**KIRKLEES METROPOLITAN COUNCIL
INVESTMENT & REGENERATION SERVICE**

Reference No: 2021/62/91976/E

Site Address: 105, Marsh Lane, Shepley, Huddersfield, HD8 8AP

Description: Demolition of conservatory, increase in roof height and formation of dormers and erection of attached garage

client	LA DEVELOPMENTS		
project	EXTENSION & ALTERATIONS TO 105 MARSH LANE, SHEPLEY HUDDERSFIELD, HD8 8AP		
drawing	PROPOSED PLANS AND ELEVATIONS		
revision	notes	date	drawn
*	*	*	*
scale :	1:100 AT A1	04.21	MG
project no.	1753	drawing no.	02
		revision	-

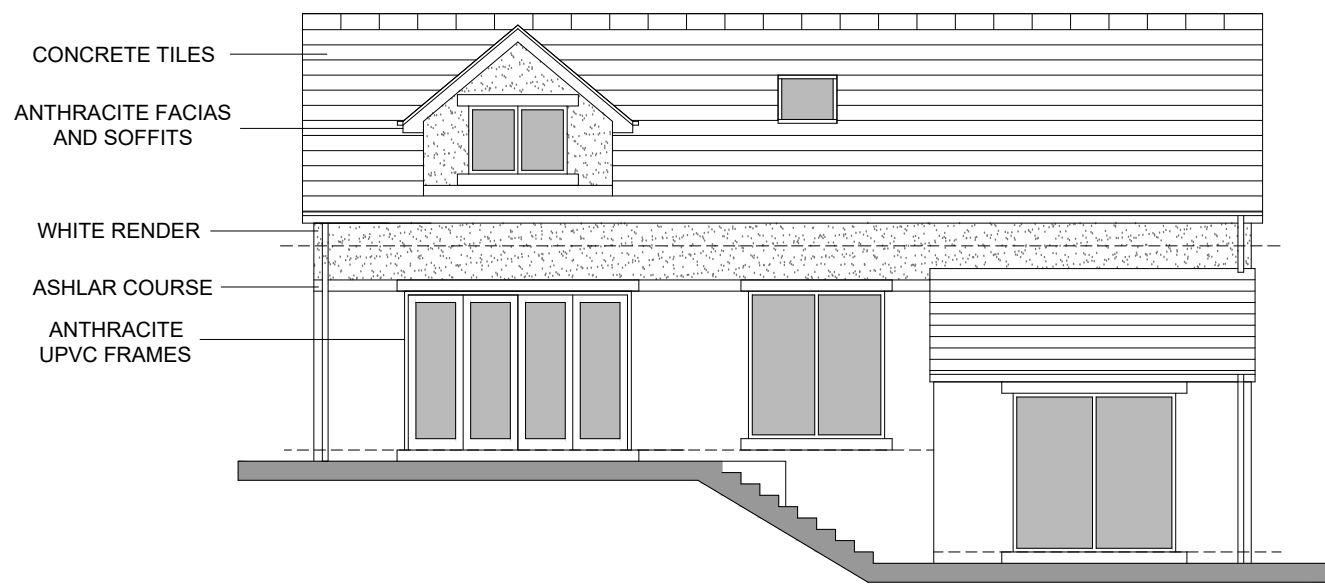
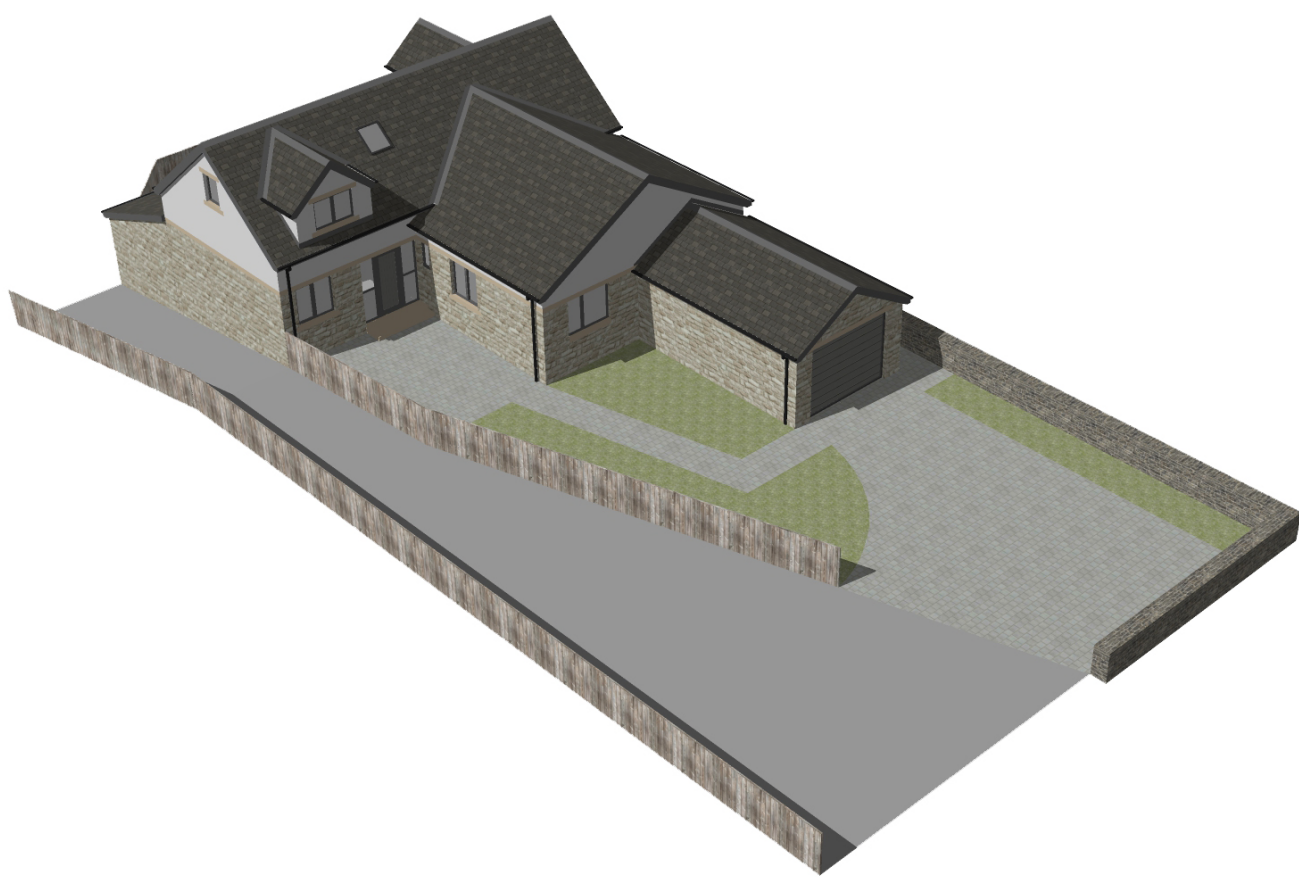
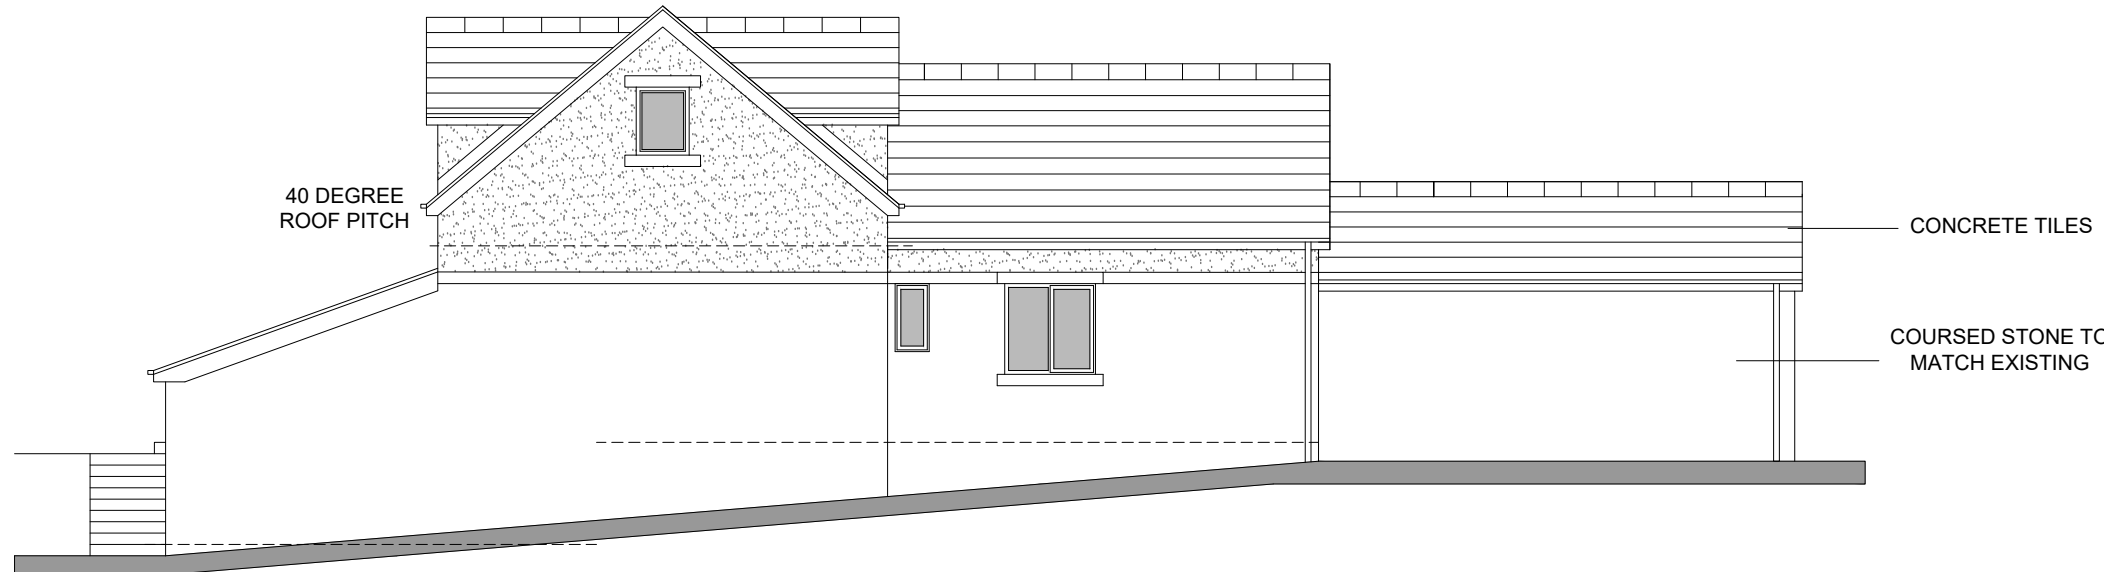
The increased massing would not cause undue loss of light to this property, given the approx. 13.5m retention at the closest point and the space about the properties. The proposed east facing side elevation gable window, serving the bedroom, would be conditioned to be obscure glazed given that it is not the primary window to this bedroom, to preserve the privacy of rear fenestration windows at no. 103. The proposed front elevation bedroom windows would not

The proposed west facing gable side window would be conditioned to be obscure glazed as it does not form a primary window to the room it serves; a bedroom. In any case this window would not directly overlook habitable room windows at no. 107. The space about the properties and set back of the application site host dwelling compared to no. 107 largely negates any loss of light concerns here.

Concerns raised in representation pertaining to amenity have been borne in mind and as such, following an assessment, conditions will be appended to the Decision Notice obscure glazing the side first floor gable end windows to ensure an appropriate level of privacy is maintained to neighbouring properties.

3. The first floor gable end windows at the south west facing and north east facing side elevations, shown serving the bedrooms, shall be permanently glazed to a minimum of level 3 on the Pilkington scale of obscuration or industry equivalent and non-opening to a height not less than 1.7m from finished floor level. Note that the application of translucent film to transparent glass fails to satisfy the requirements of this condition.
